Recommendation Report for Planning Permission for Works or Extension to a Dwelling

REF NO: AW/147/18/HH

LOCATION: 29 Fernhurst Gardens
Bognor Regis
PO21 4BA

PROPOSAL: Single storey rear extension.

ELEVATIONS [As Proposed]

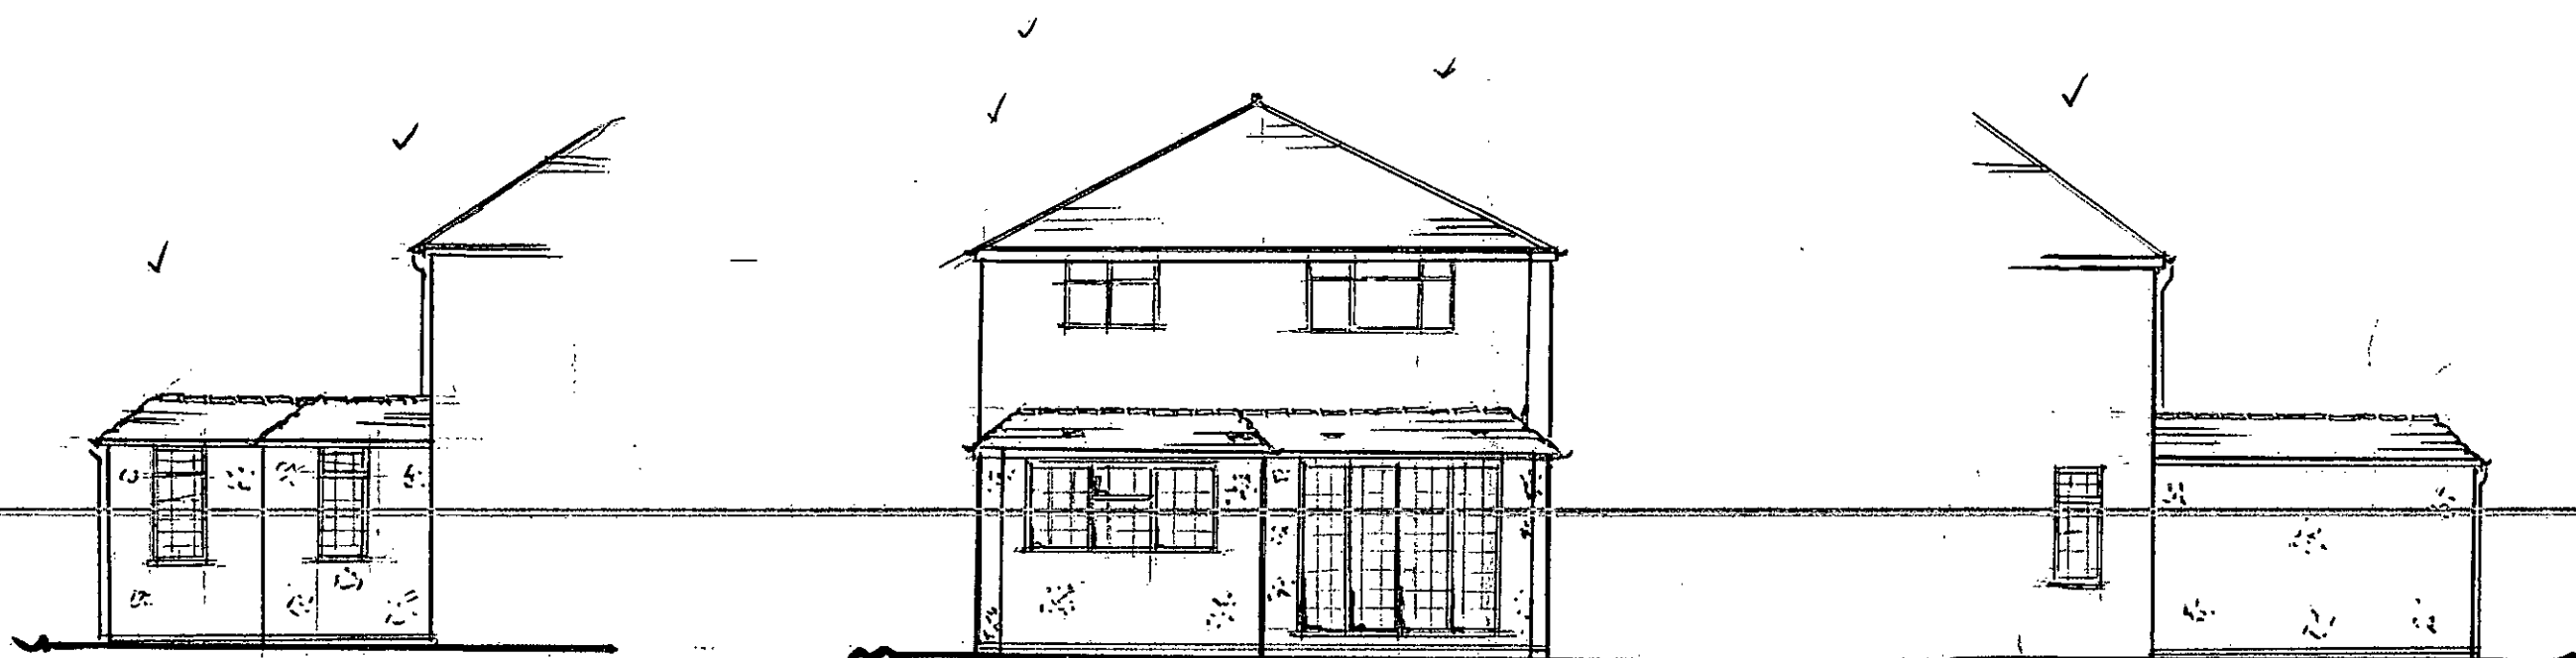
The maximum height of the proposed development is 3.3m from ground level. This is approximately 4m lower than the existing ridge height of the host dwelling. Therefore, the proposed development is considered to appear subservient, nor is it deemed to harm its established character.

The proposal has a maximum height of 3.3m, this is set over 4m from the closest dwelling to both the North, and the South. This is considered to prevent any significantly detrimental impact on the neighbouring amenities of adjacent occupiers. There is not considered to be a significant loss of privacy as whilst the proposal features windows on its Southern elevation, any views would be impeded by the fencing and mature foliage that lies between the two properties. Resultantly, the proposed development is considered to be in accordance with D DM1(3) and D DM4(c) of the Arun District Council Local Plan (2011-2031).
